# City of Albuquerque Stormwater Construction Site Inspection Report

ESC File No.	R16E100	Project Name:	Bobby Foster Blvd. and University Blvd. Improvements Phase 1		
NPDES Id. No.	NMR1003I5/NMR1003OM	Location:	Bobby Foster Blvd. and University Blvd.		
11/5/2024	Owner	Contractor			
Operator	MDS Investments, LLC	Guzman Construction Solutions, LLC.			
Contact name & title	Eddie Gonzales	Eddie Gonzales			
e-mail	<a href="mailto:eddie@guzmancs.com">eddie@guzmancs.com</a>	<a href="mailto:eddie@guzmancs.com">eddie@guzmancs.com</a>			
Contact Phone #	505-452-0663	505-452-0664			
COA Inspector	Chancellor English	Start/End Time:	12:30-1:30pm		
Construction Phase:	Grading, infrastructure				
Type of Inspection:	<input checked="" type="checkbox"/> Regular	<input type="checkbox"/> Storm Event	<input type="checkbox"/> Past Storm Event >0.25"	<input type="checkbox"/> 311/Complaint	<input type="checkbox"/> Follow Up
Weather at time of inspection?	clear		Temperature: ~	60	
Estimated date of last storm 0.25" or greater	11/4/2024

SHEET:
COVER

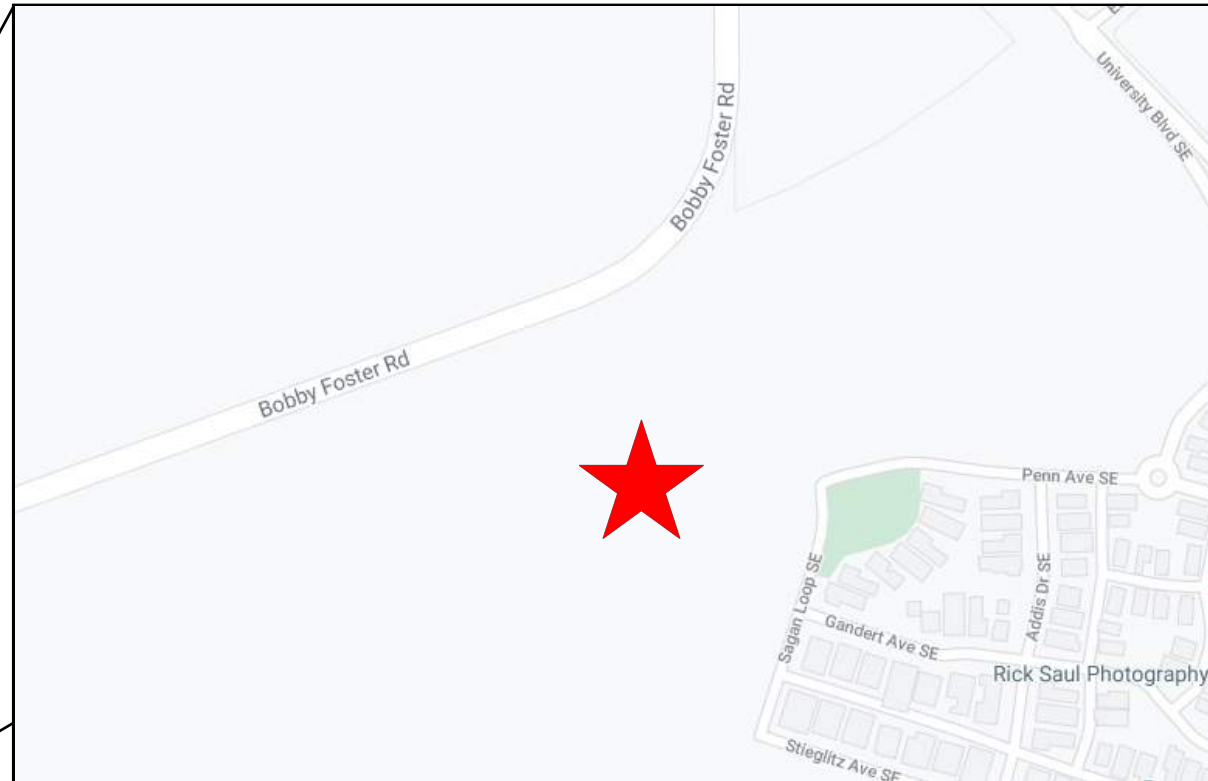
Heavy equipment is being parked in the stockpile area adjacent to the Montage Units 5 and 6. If the developers are allowed to store the equipment on your property, your SWPPP map will need to be amended to reflect equipment storage along with the stockpiles.
